From: [REDACTED]
Sent: 24 November 2025 23:15
To: Planning
Subject: Objection to Planning Application Reference 3/2025/0870

I OBJECT to the planning application 3/2025/0870 for the proposed development at 18 Accrington Road, Whalley, on the grounds of design, scale, massing and visual impact.

Drawing Title
Proposed Floor Plans and Elevations

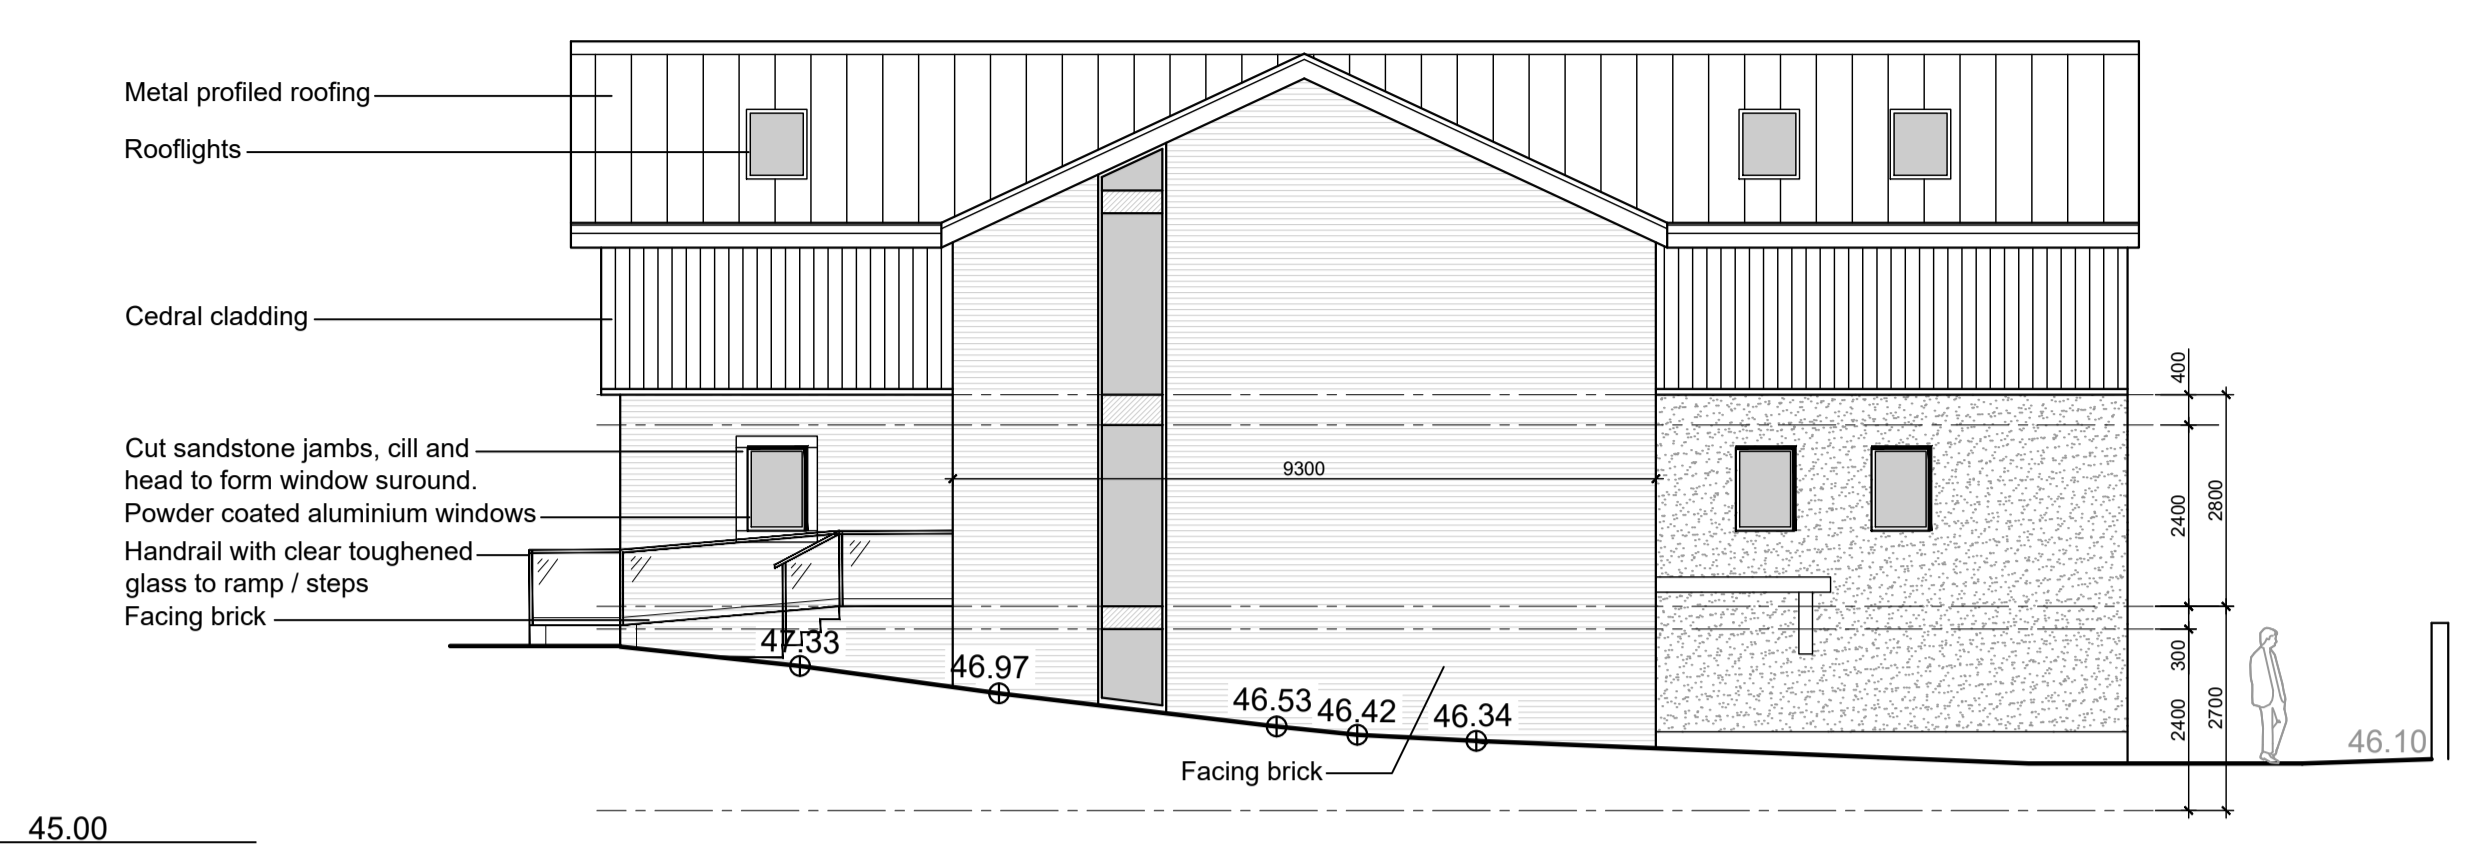
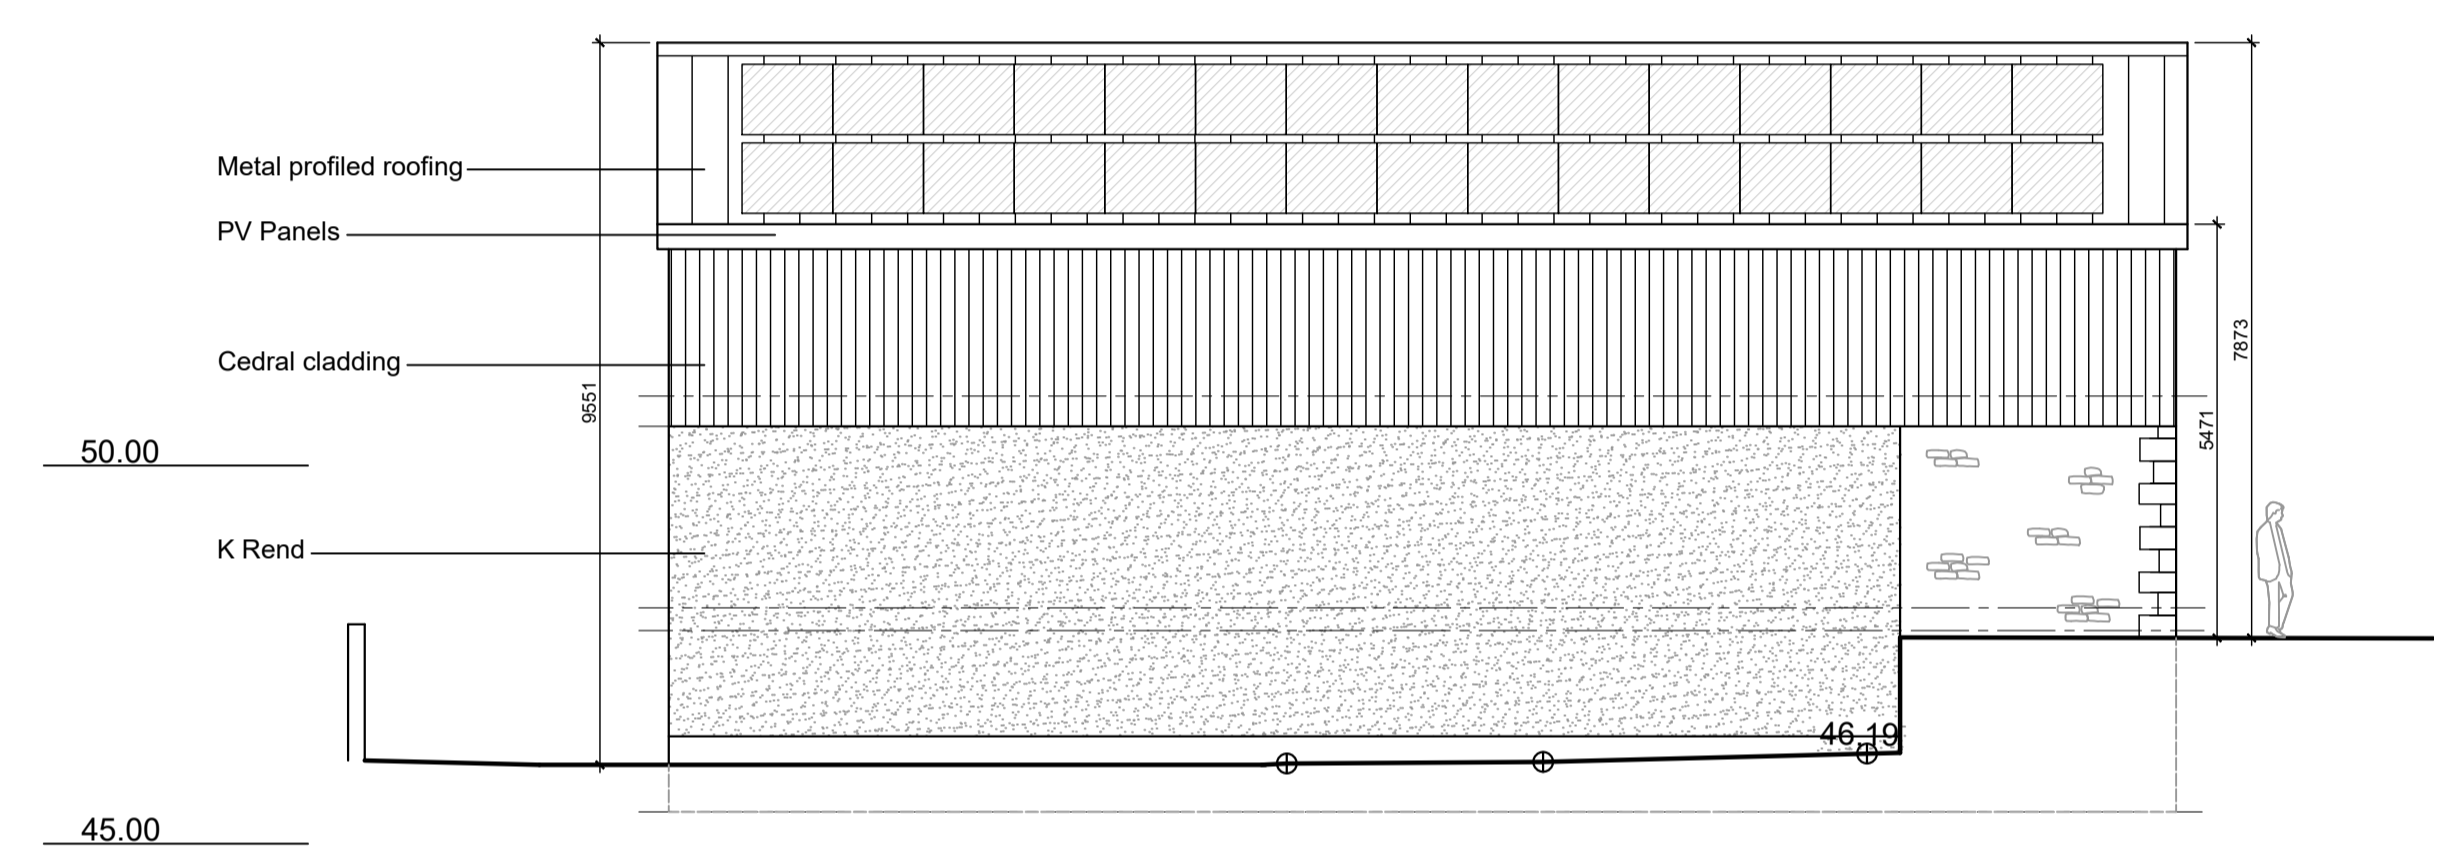
The increased ridge height and larger side gable would have a negative visual impact on the views to Whalley Nab, introducing an excessive built form that erodes the area's character and the public visual amenity experienced along Accrington Road.

This impact is particularly concerning, given the site's proximity to the proposed extension of the Whalley Conservation Area.

The development would undermine the historic and visual coherence that contributes to Whalley's distinct character and setting.

This conflicts with Policy DME4 (Protecting Heritage Assets) of the Core Strategy 2008 - 2028, which seeks to ensure that " proposals affecting views into or out of Conservation Areas do not have an adverse impact on the special architectural or historic character and appearance of the area".
